CITY OF ALBUQUERQUE

Re: 7501 Holly Ave., Guardian Storage
Temporary Certificate of Occupancy – Transportation Development
Engineer's/Architect's Stamp dated 01/14/14 (C19/D056)
Certification dated 01/21/14

ARCHITECTURAL SITE PLAN FOR BUILDING P GUARDIAN SELF STORAGE

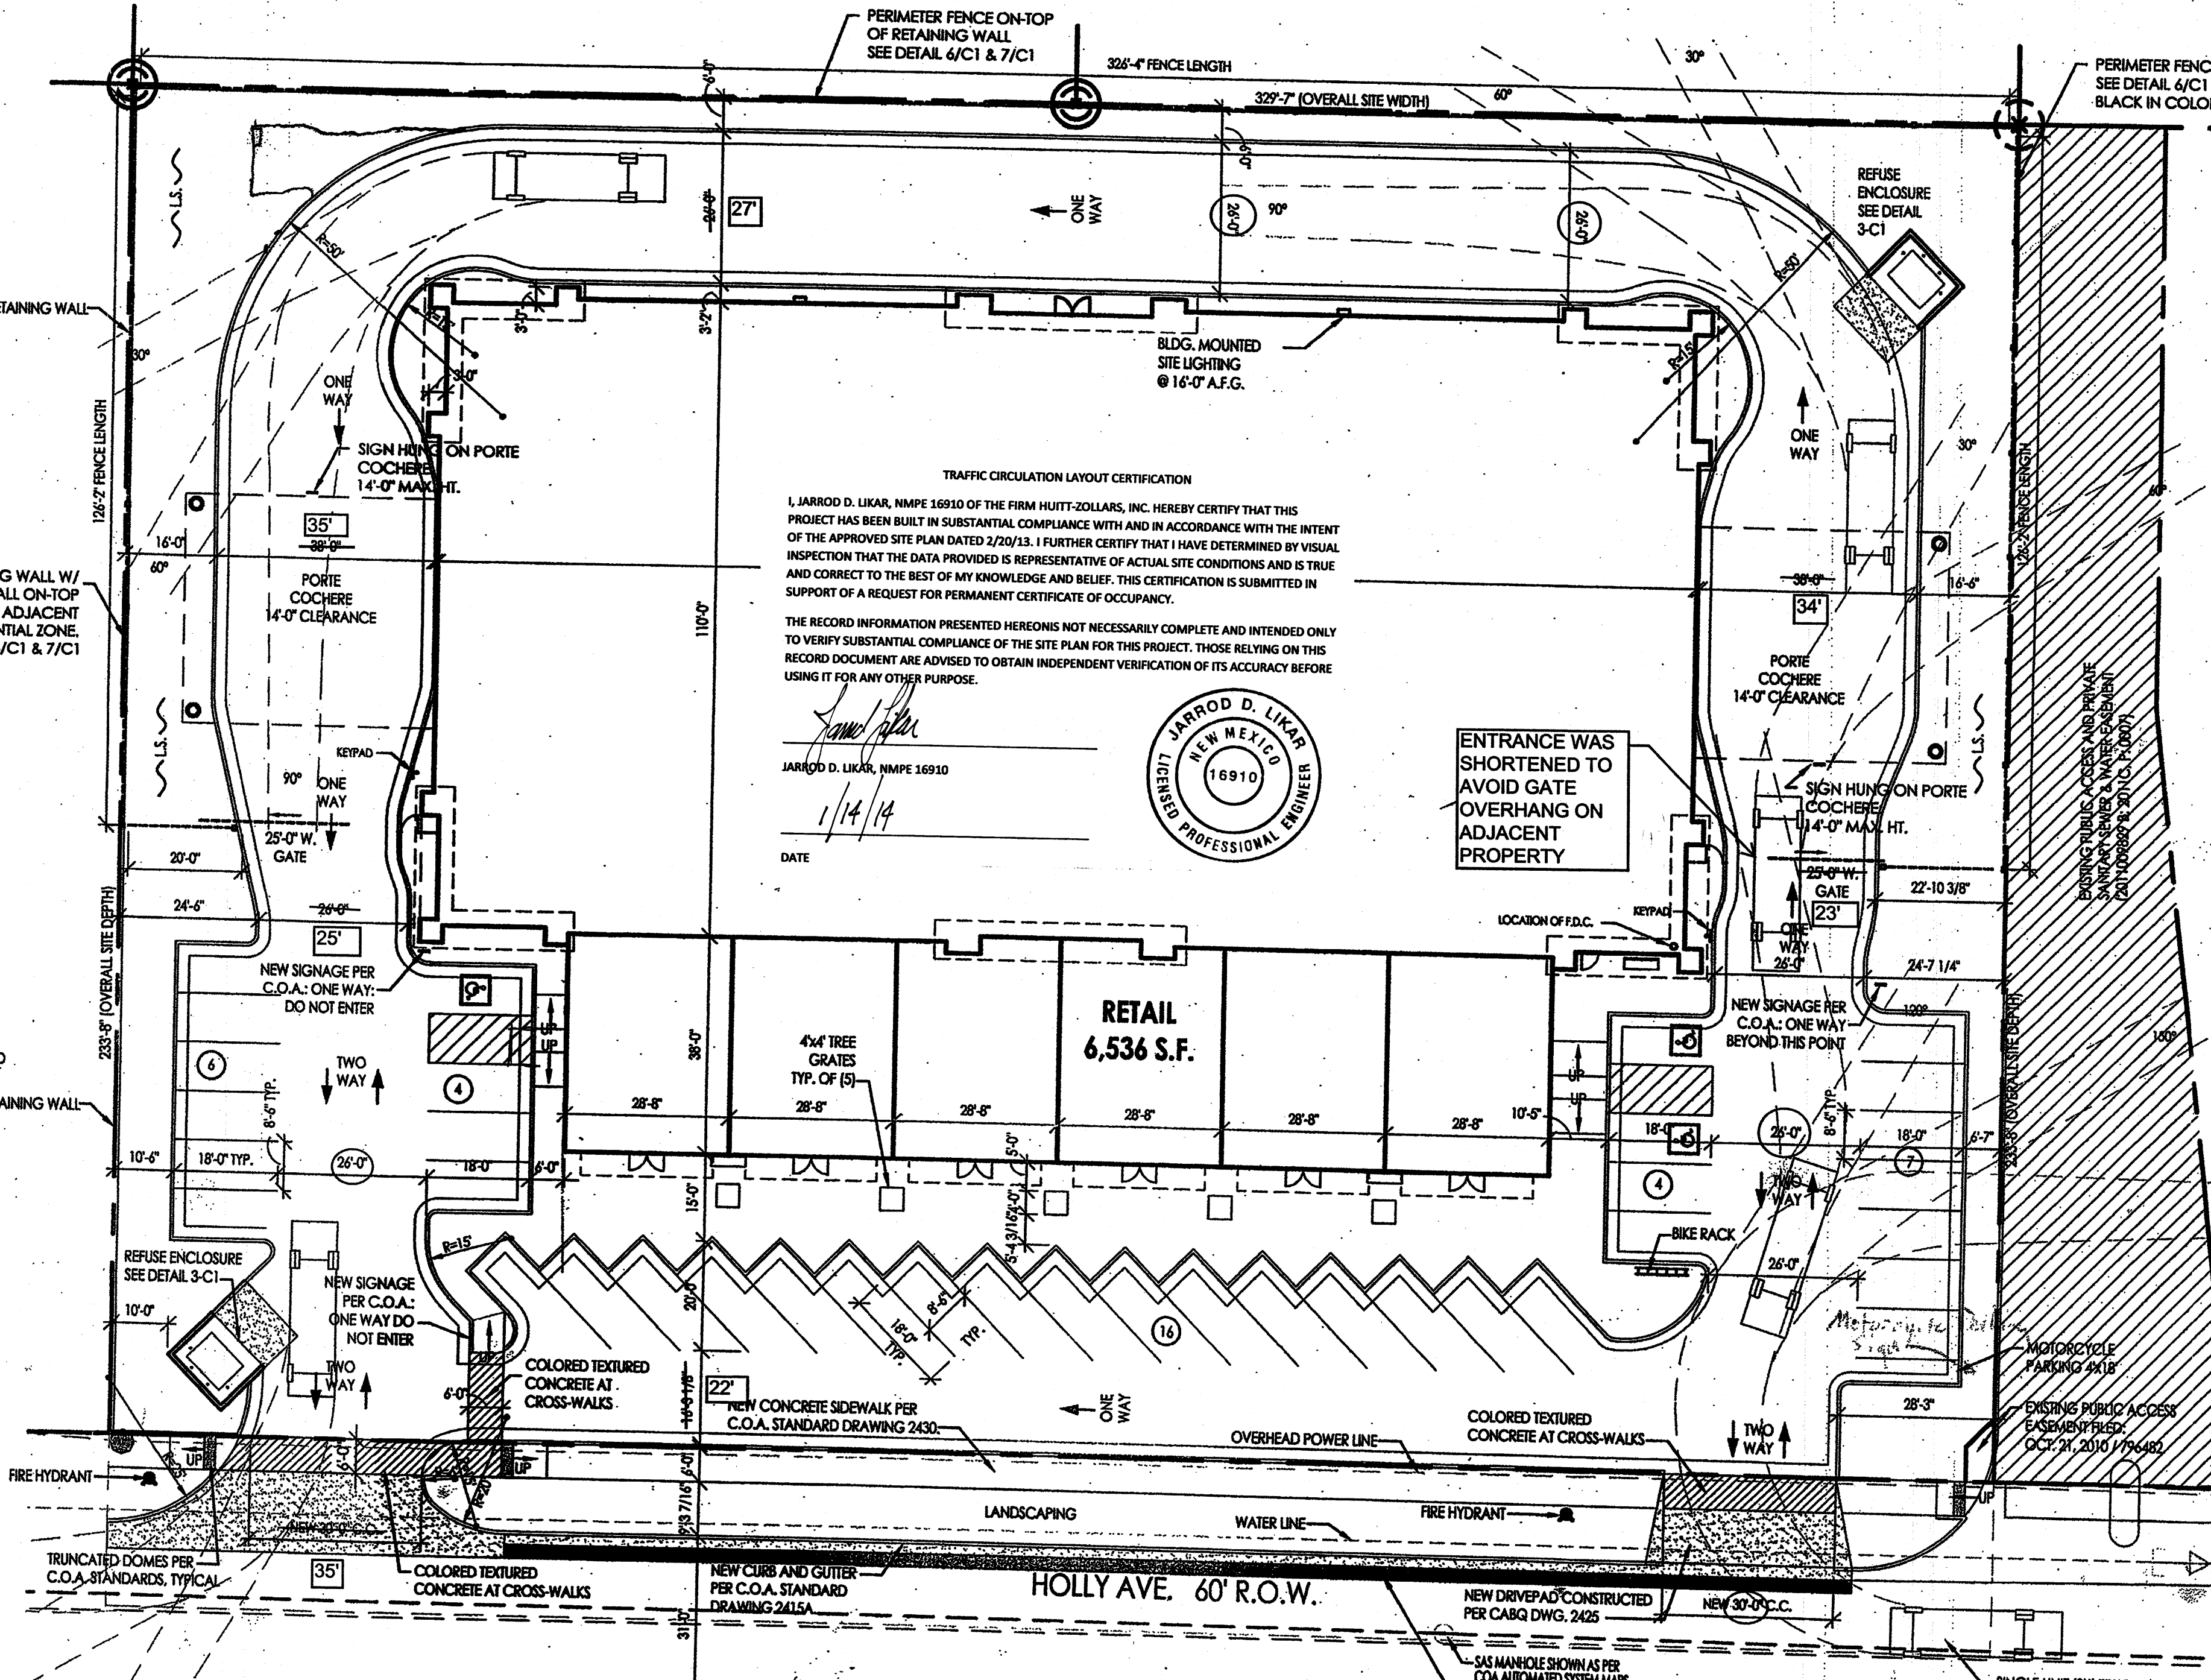
After review of the site we must rescind the Permanent TCL Certificate of Occupancy dated Jan 21, 2014. The fire department required that the area in front of the fire department connection be striped as a no parking lane. This resulted in the loss of a handicap accessible parking space. There was a parking requirement for 37 spaces including 3 HC spaces under the approved Site Development Plan for Building Permit (1009245) which the site does not now meet.

- Relocation of the handicap accessible parking space.
- Completion of an Administrative Amendment for changes to the site plan.
